Consultation Response from KC, Conservation & Design
2026/90657 6, Nelson Street, Dewsbury, WF13 1NA
Listed Building Consent for replacement of specified external doors and windows with like-for-like units (within a Conservation Area)
Date Responded: 1/5/26 Responding Officer: SC Responding Ref:

This response is in respect of both applications 2026/90656 and 2026/90657.

This building is Grade II listed and within the Conservation Area.

Timber Sash Window Section Detail
Existing (1:5)

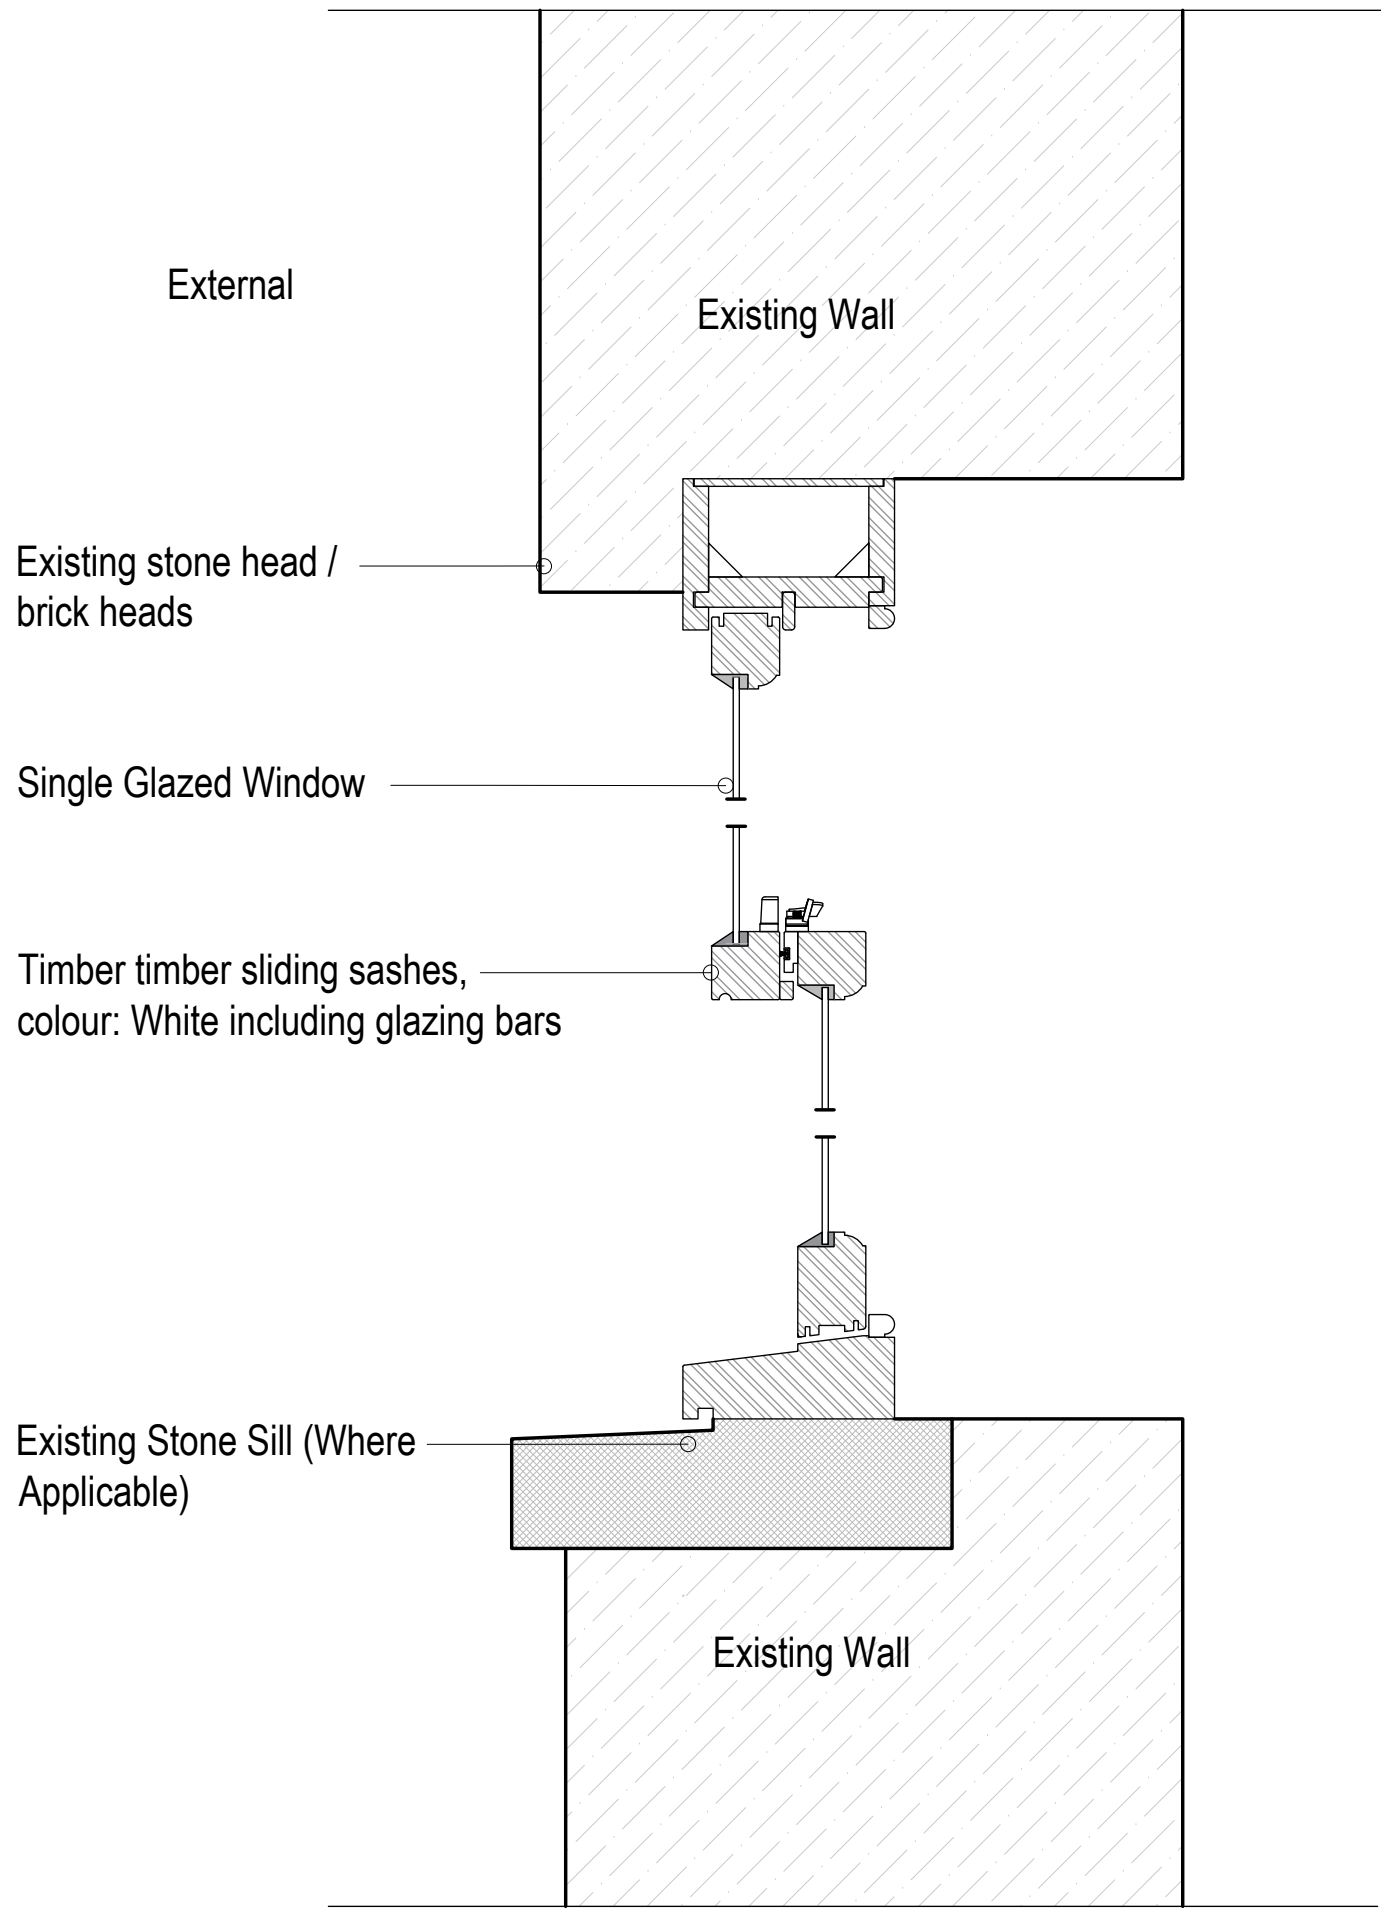
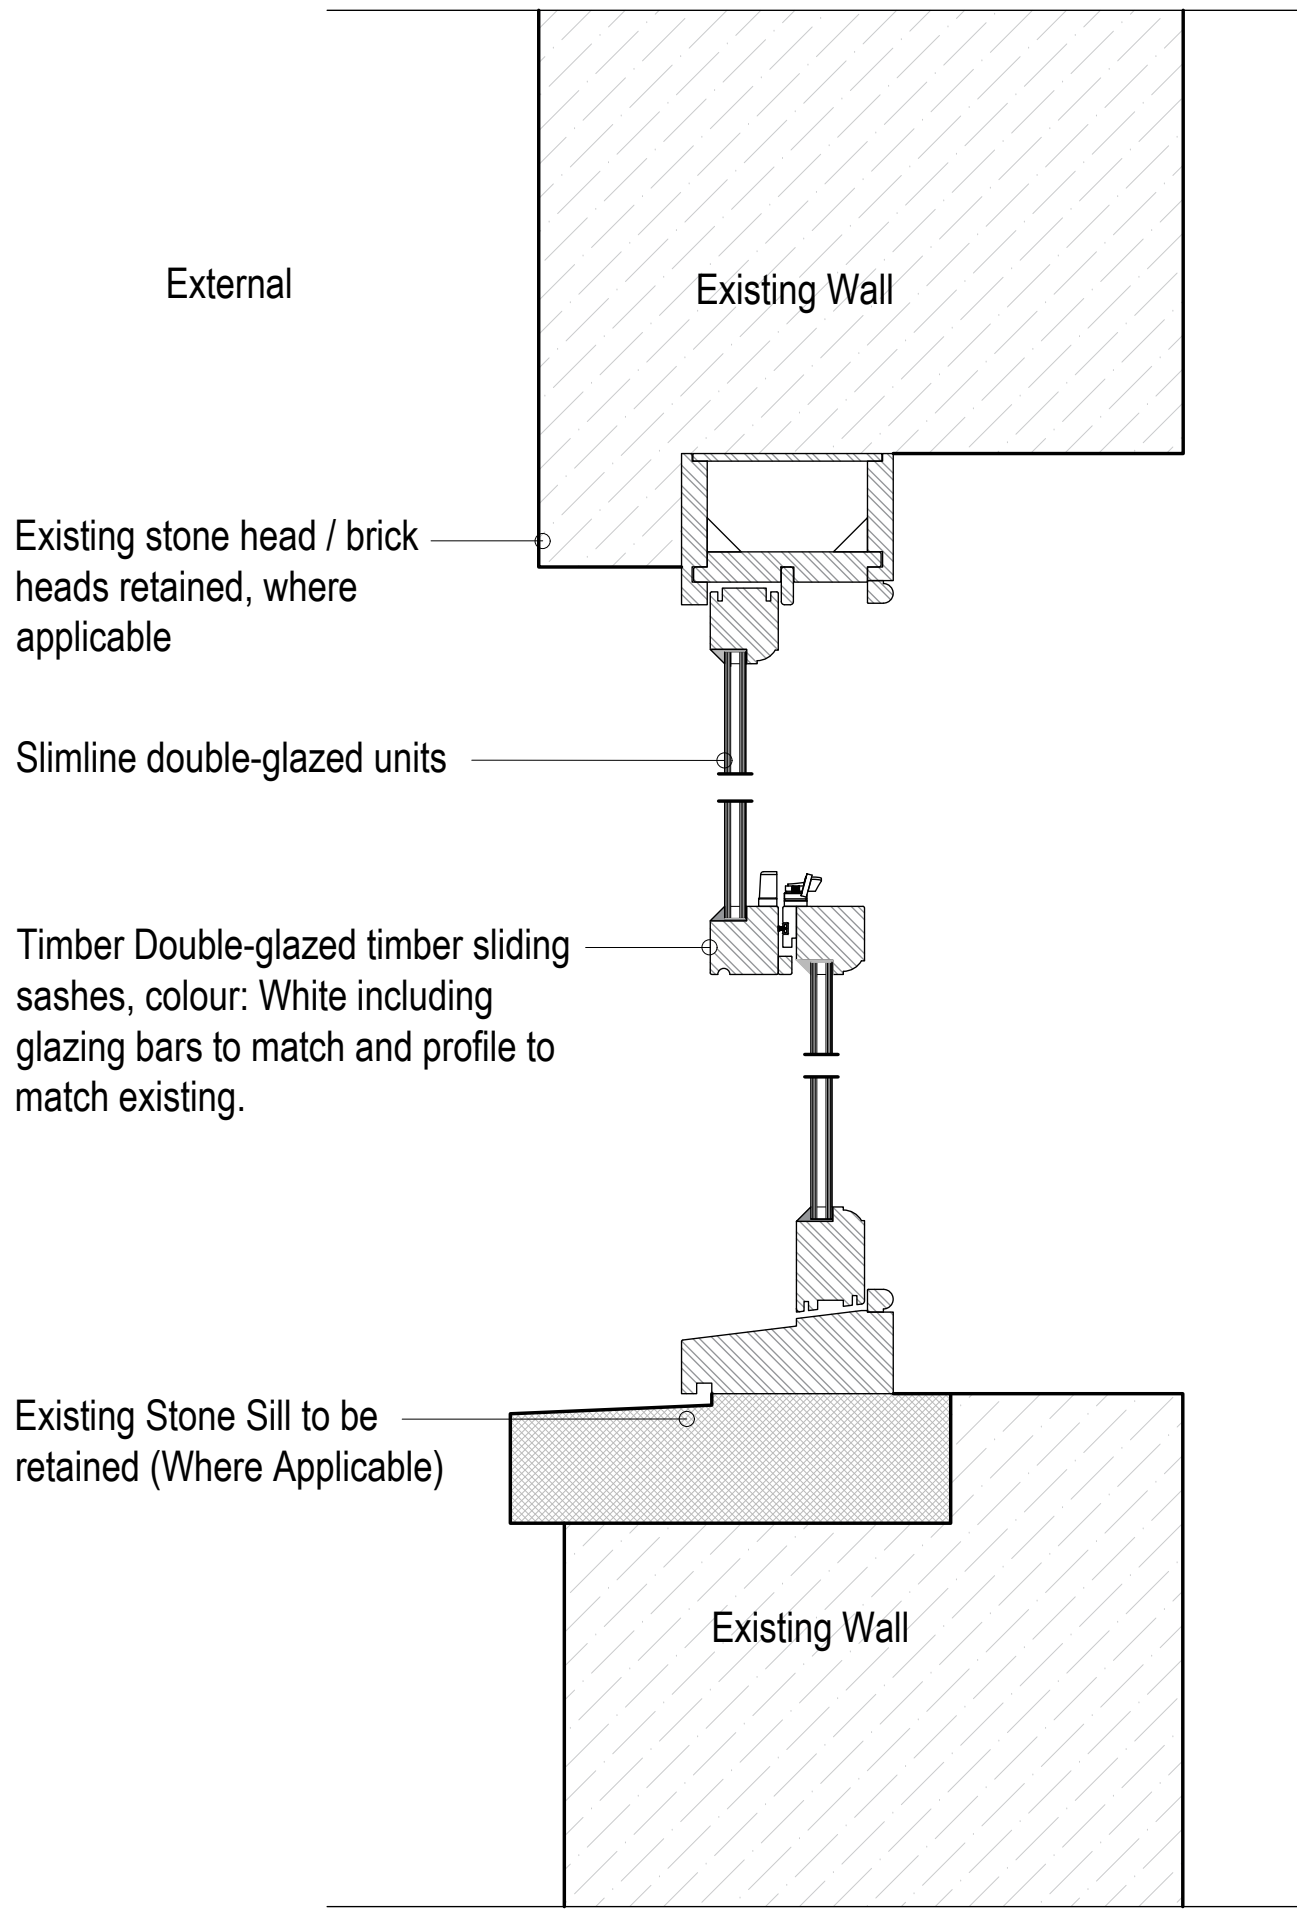
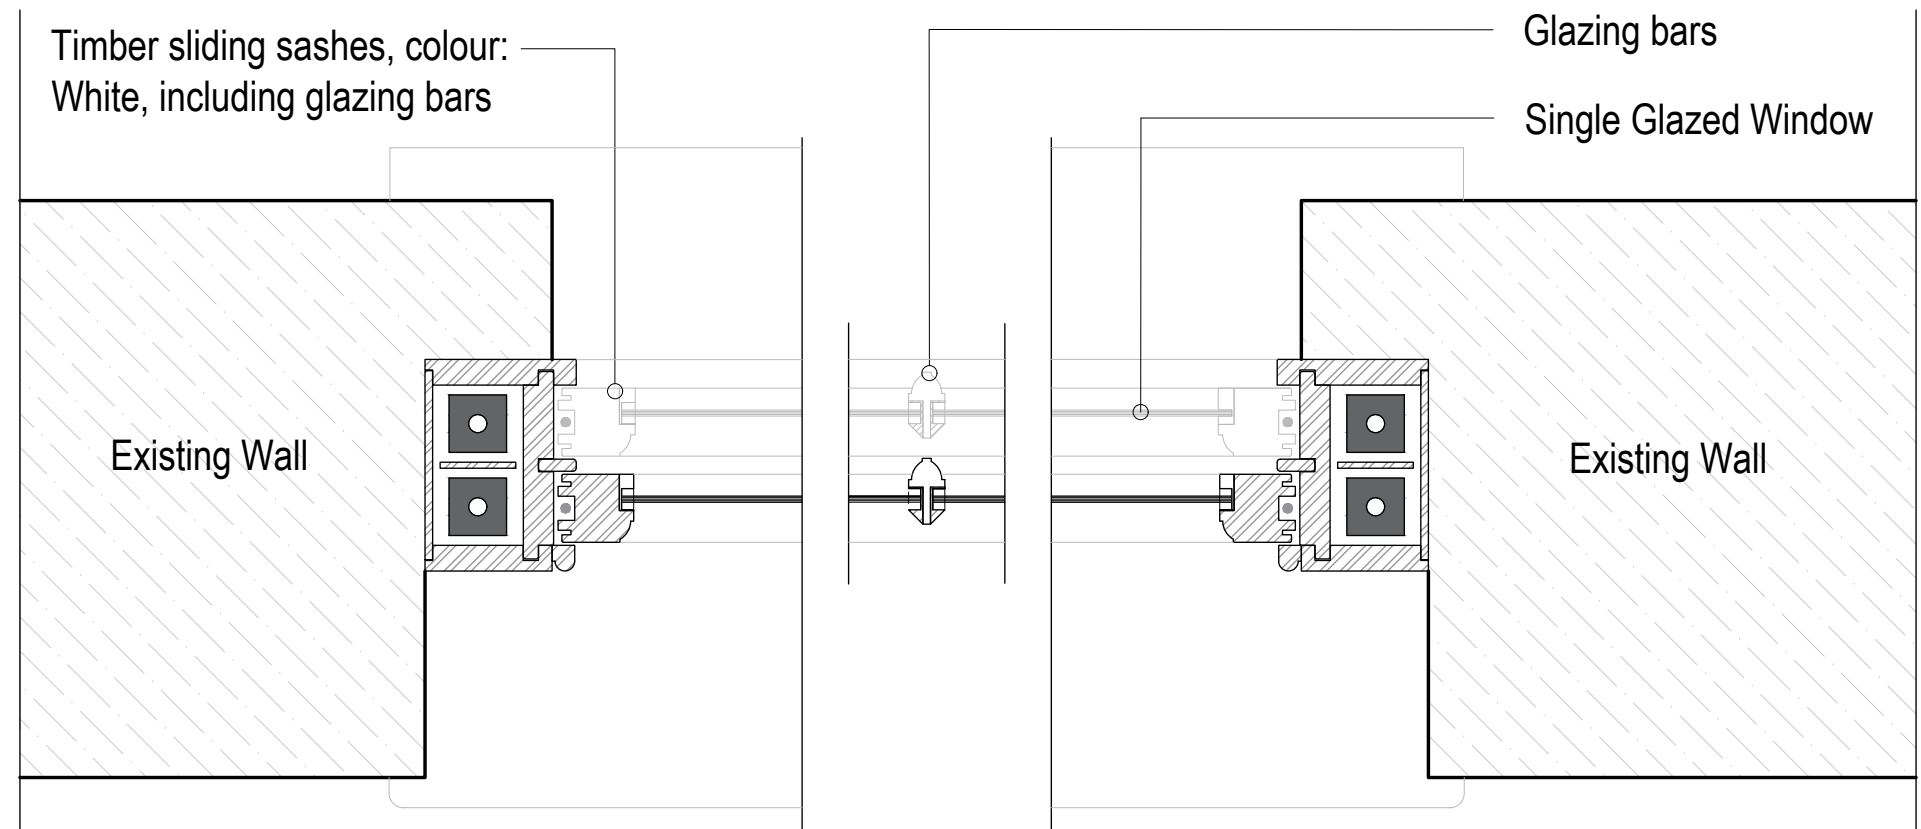
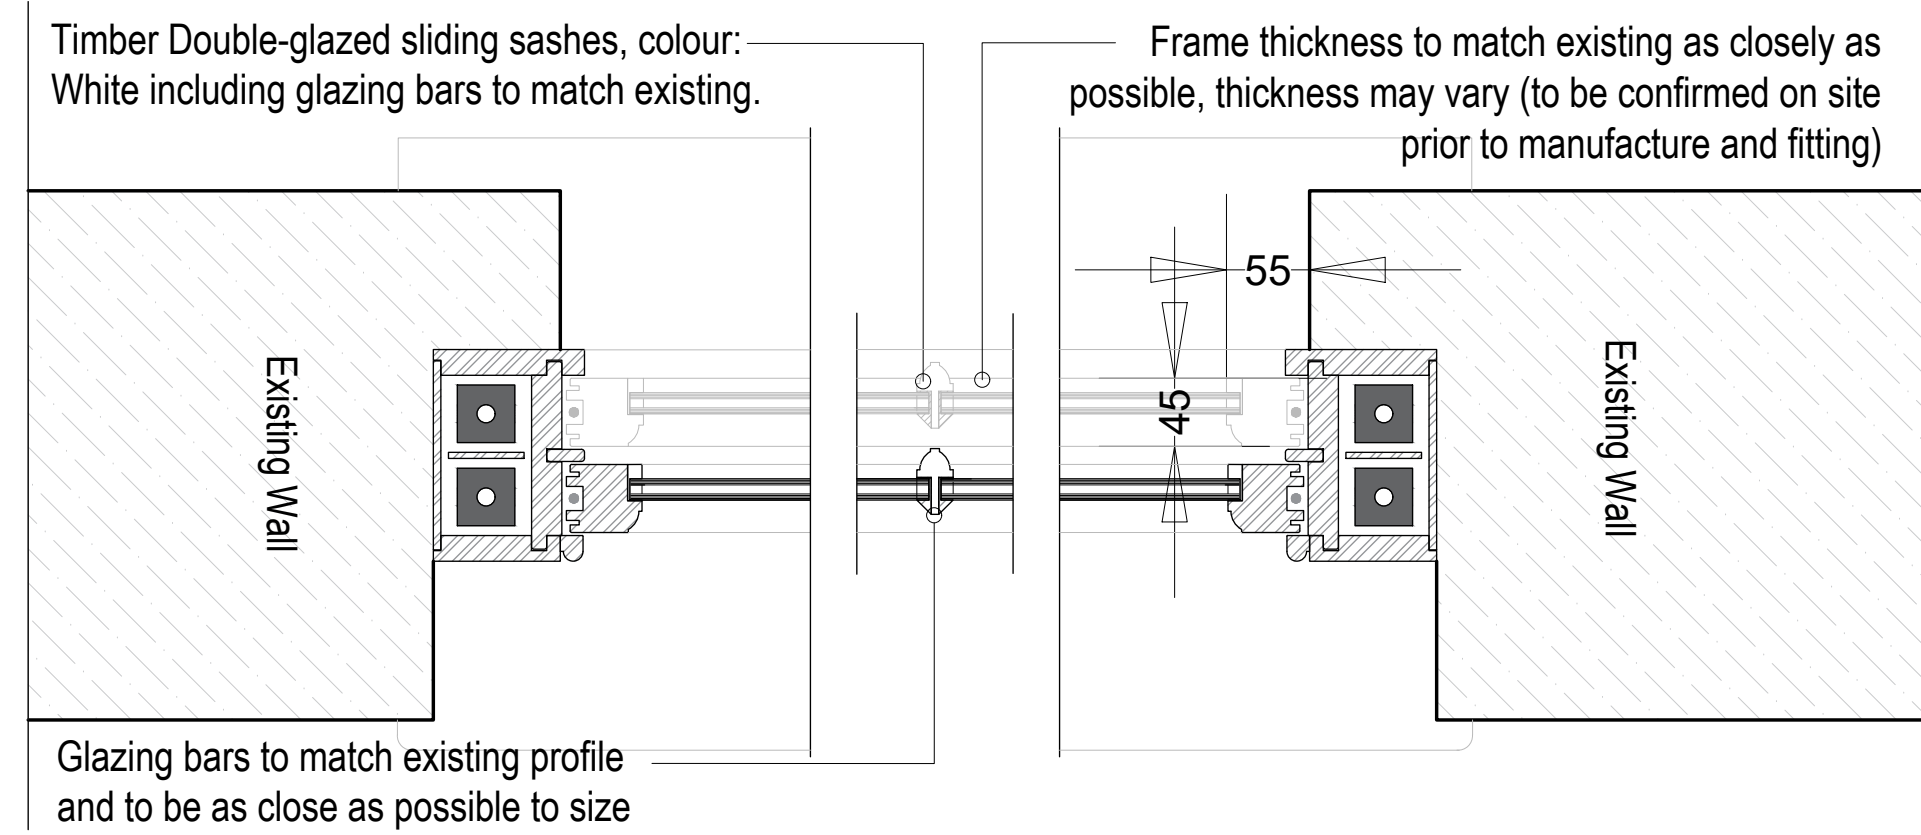
Slimlite double glazing is proposed and sections submitted stating 'frame thickness to match existing as closely as possible, thickness may vary (to be confirmed on site prior to manufacture and fitting).' A condition is to be imposed to ensure the details will be appropriate.

1. Notwithstanding the details provided, all windows shall match the existing joinery details in terms of material, profiles, detailing, dimensions, albeit with an increase in the internal section sufficient to accommodate slim double glazing. All slim double-glazed units shall have a maximum of 4mm glass with an 8mm gap with black spacer bars.
